**KIRKLEES METROPOLITAN COUNCIL
INVESTMENT & REGENERATION SERVICE**

**DELEGATED DECISION TO DETERMINE APPLICATIONS FOR
CONSENT, AGREEMENT OR APPROVAL REQUIRED BY CONDITION**

Reference No:	2024/44/90383/E
Site Address:	Yew Tree Farm, The Village, Farnley Tyas, Huddersfield, HD4 6UQ
Description:	Discharge of conditions 3 (Phase II SI), 4 (remediation), 10 (drainage design), 11 (drainage calculations), 12 (drainage design), 26 (WSI) and 33 (highway details) of previous permission 2021/93006 for conversion of existing barn to form 8 dwellings, erection of 9 dwellings, demolition of redundant agricultural buildings and associated works (Listed Building within a Conservation Area)
Recommending Officer:	Katie Chew

Application: 2024/90383

Scale 1:250 @ A1	Date NOV 2023	Drawn HM	Checked JB
Drg No. 4011/120	Rev 1

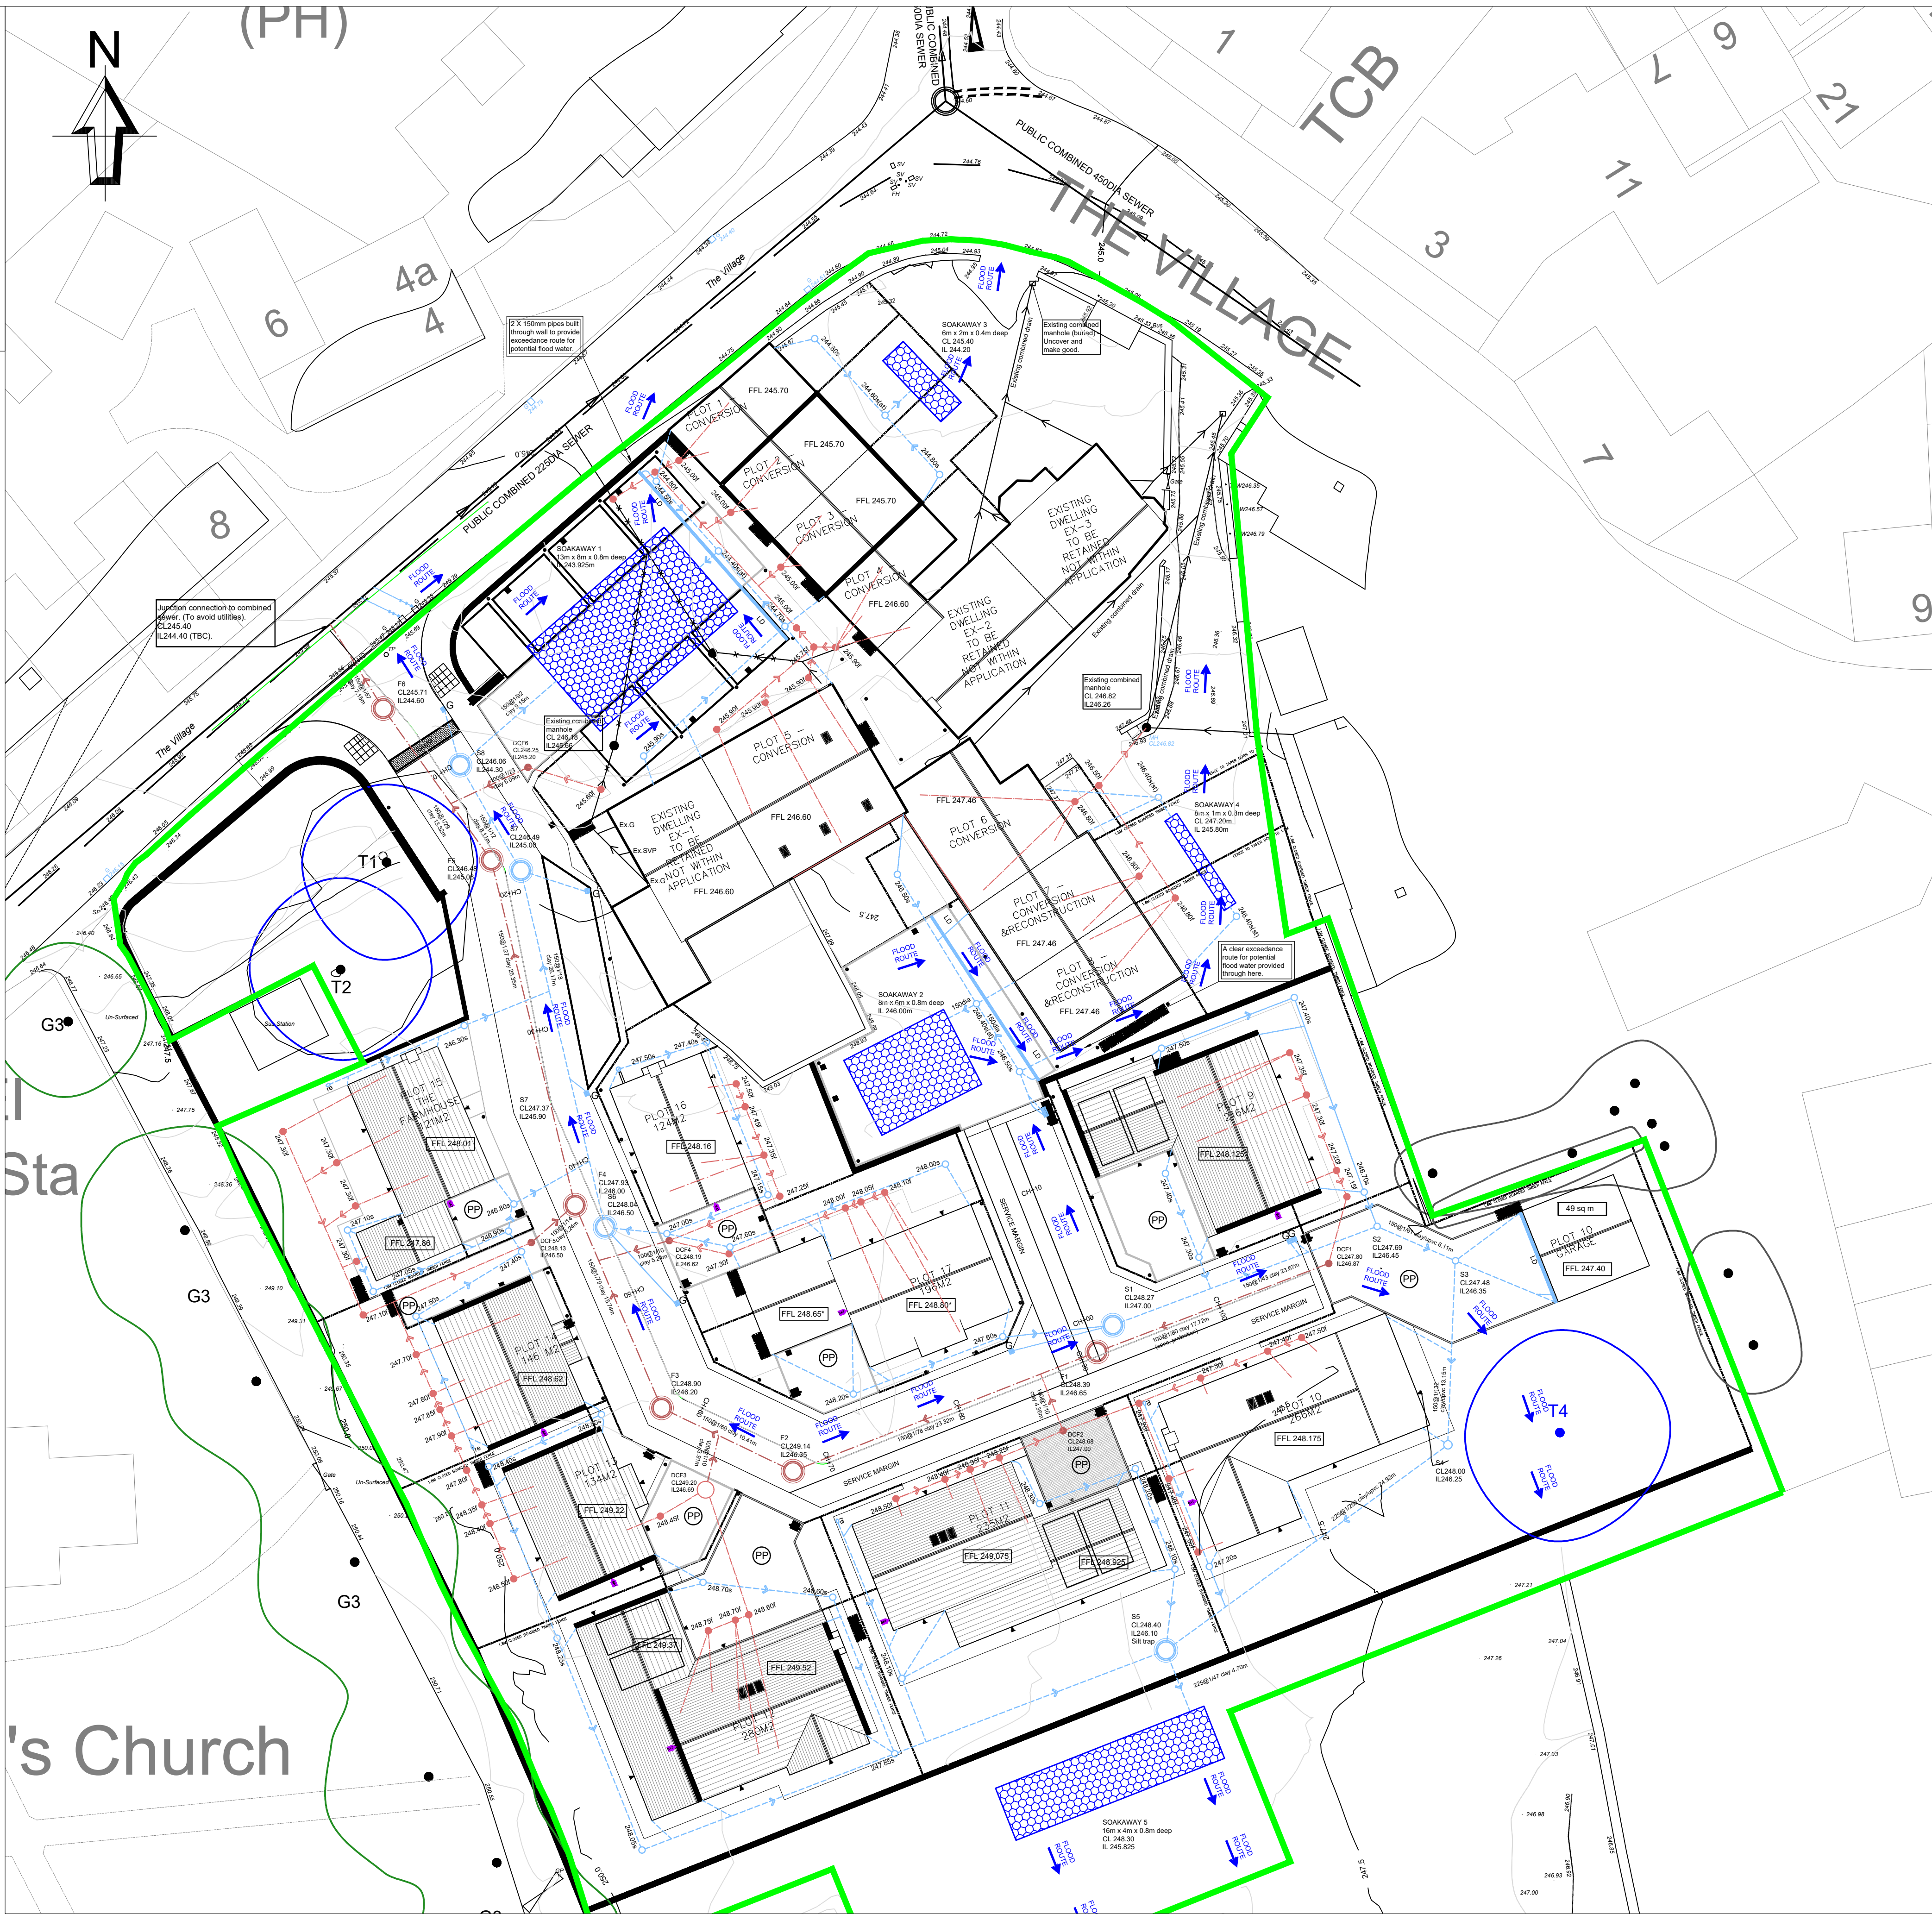
The LLFA also commented that the flood routing indicated on the Exceedance Flood Routes drawing are accepted, and condition 11 can therefore be

Drawing Title			
HIGHWAYS AND DRAINAGE			
SECTION 104 PLAN			
Scale	Date	Drawn	Checked
1:250 @ A1	NOV 2023	HM	JB
Drg No.			Rev
4011/112			2

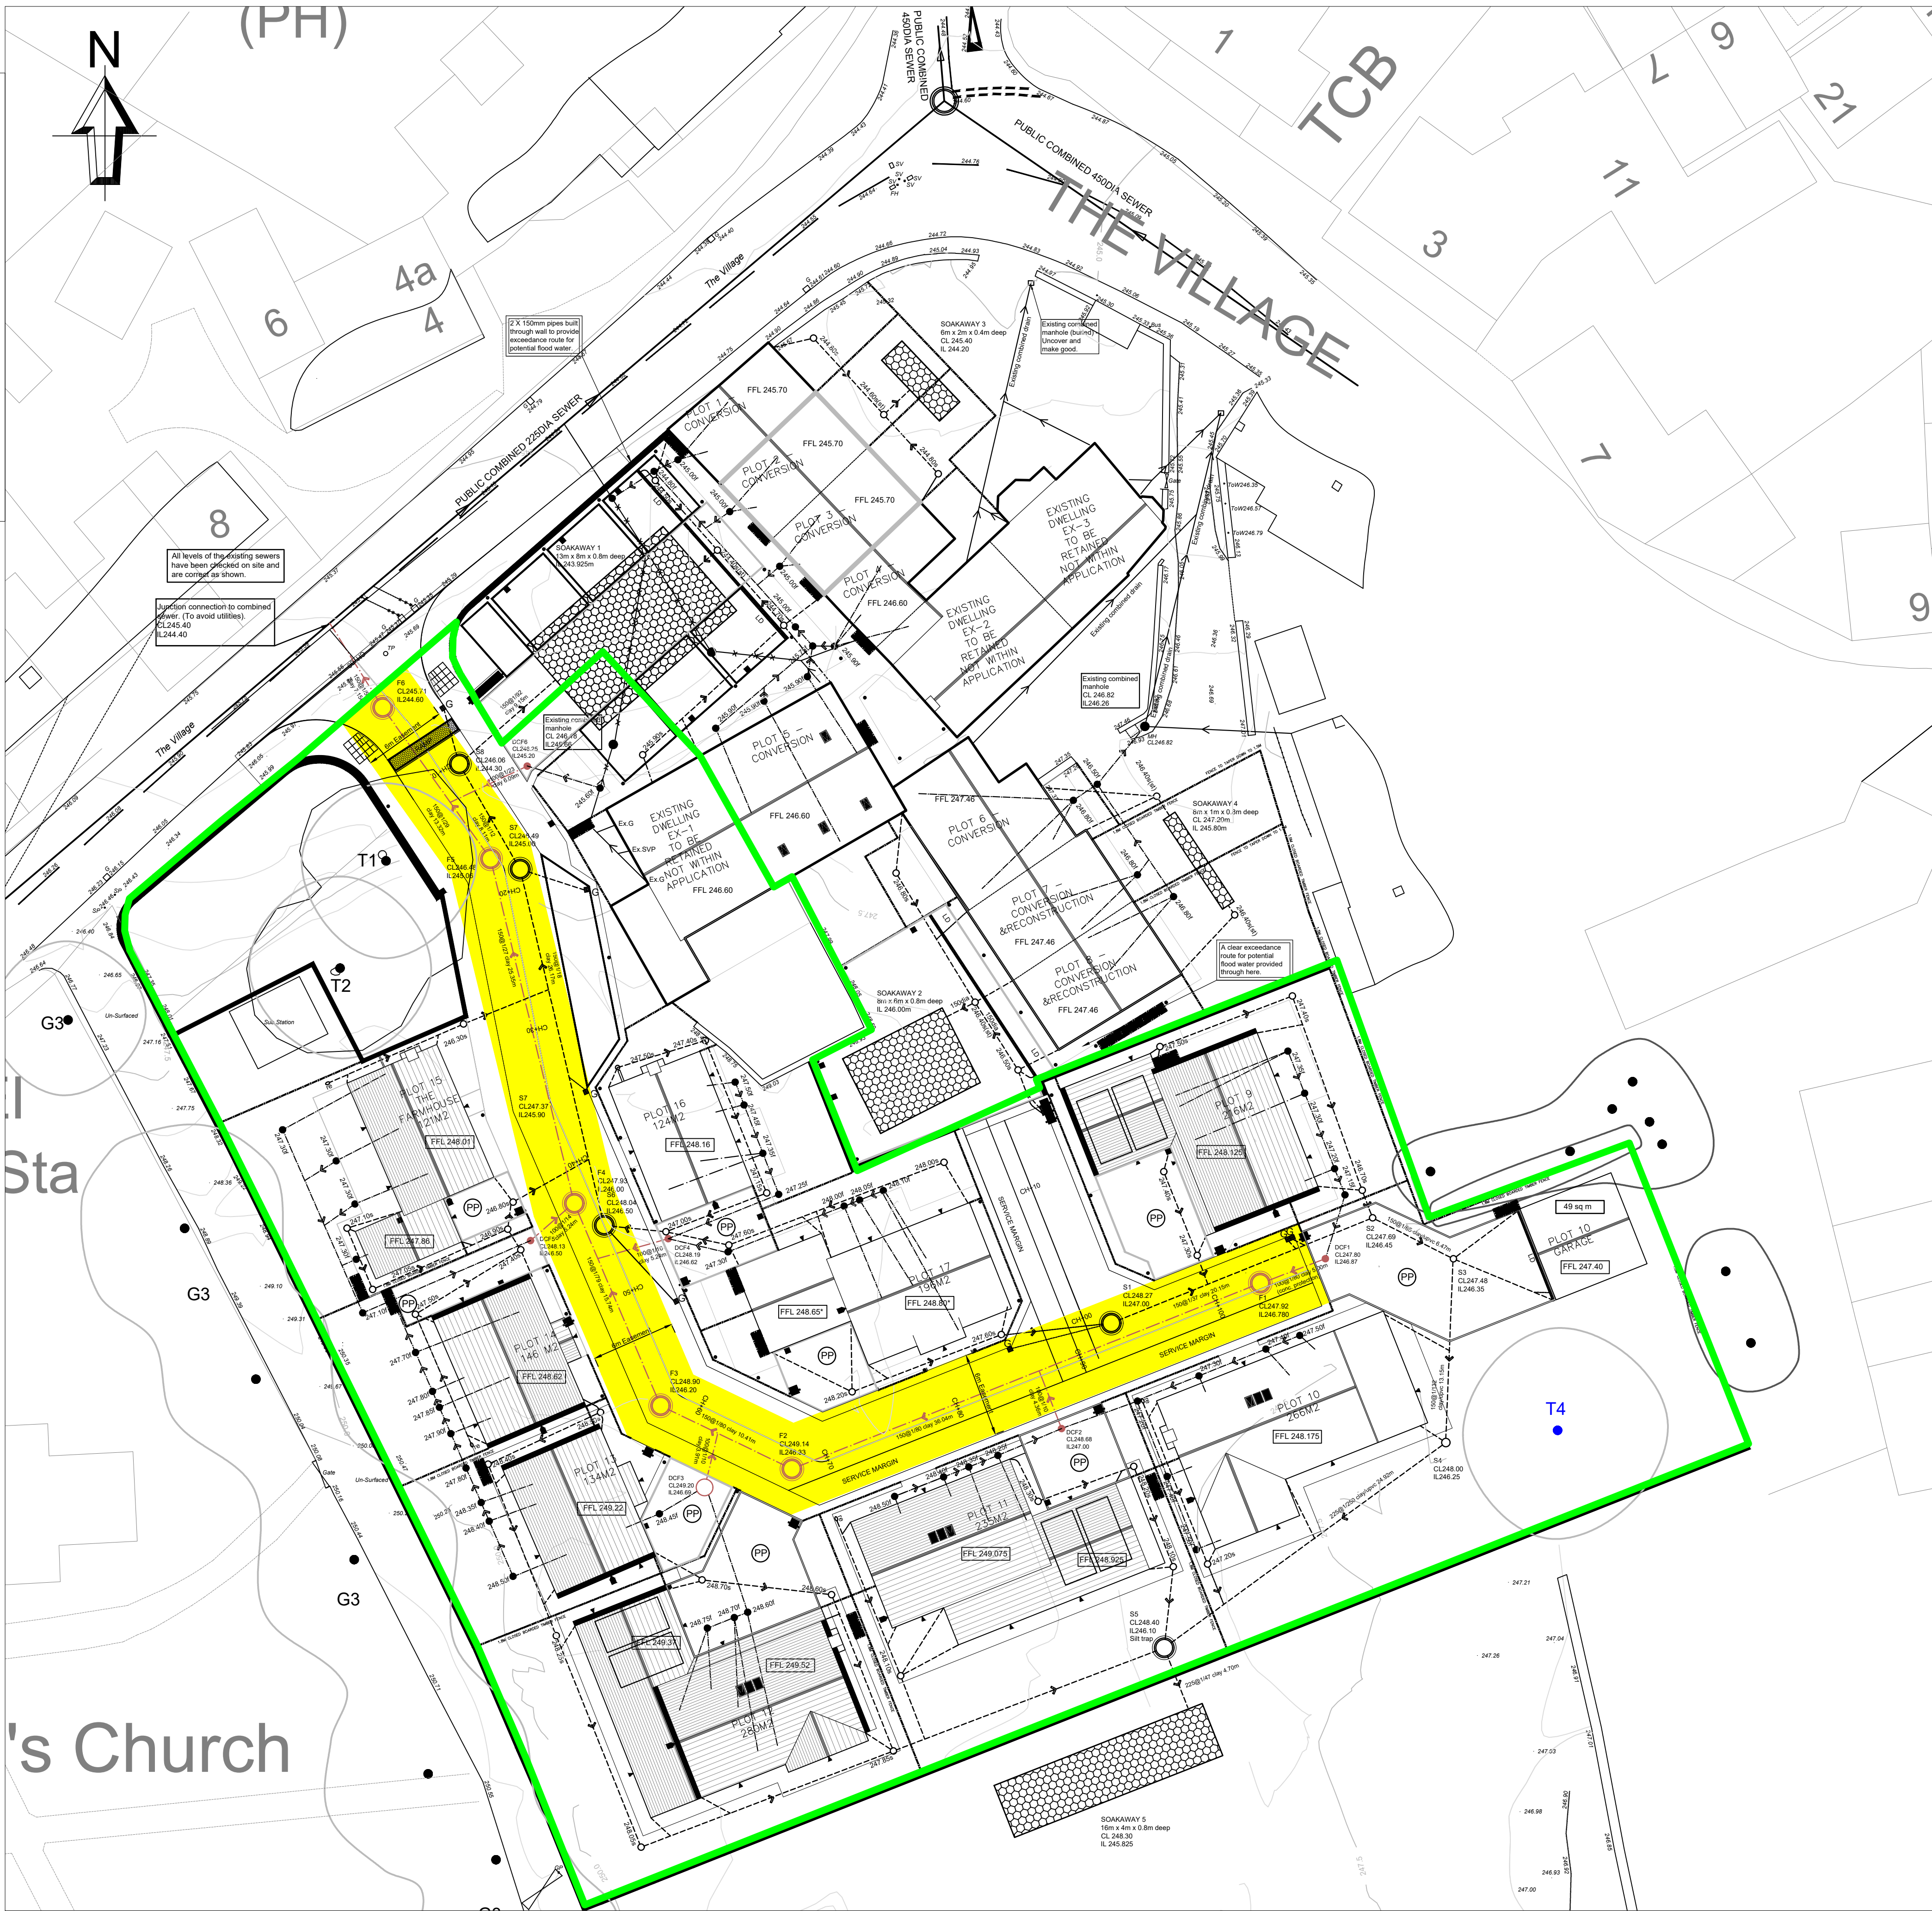
They note that the location of road gullies is shown on the Highways and Drainage Section 104 plan (drawing 4011/112 rev2) however, it is not clear from the plan what drainage is to be provided at the end of road 2. No longitudinal section has been provided to show the gradient of road 2. Furthermore, no street lighting details have been provided. Officers therefore recommend that this condition is not discharged.

Following receipt of the above comments, the applicant sought to submit a revised Highways and Drainage Section 104 Plan drawing 4011/112 rev 3, dated 11/2023, received 07/05/2024. KC HDM now have no objections to the discharge of this condition.
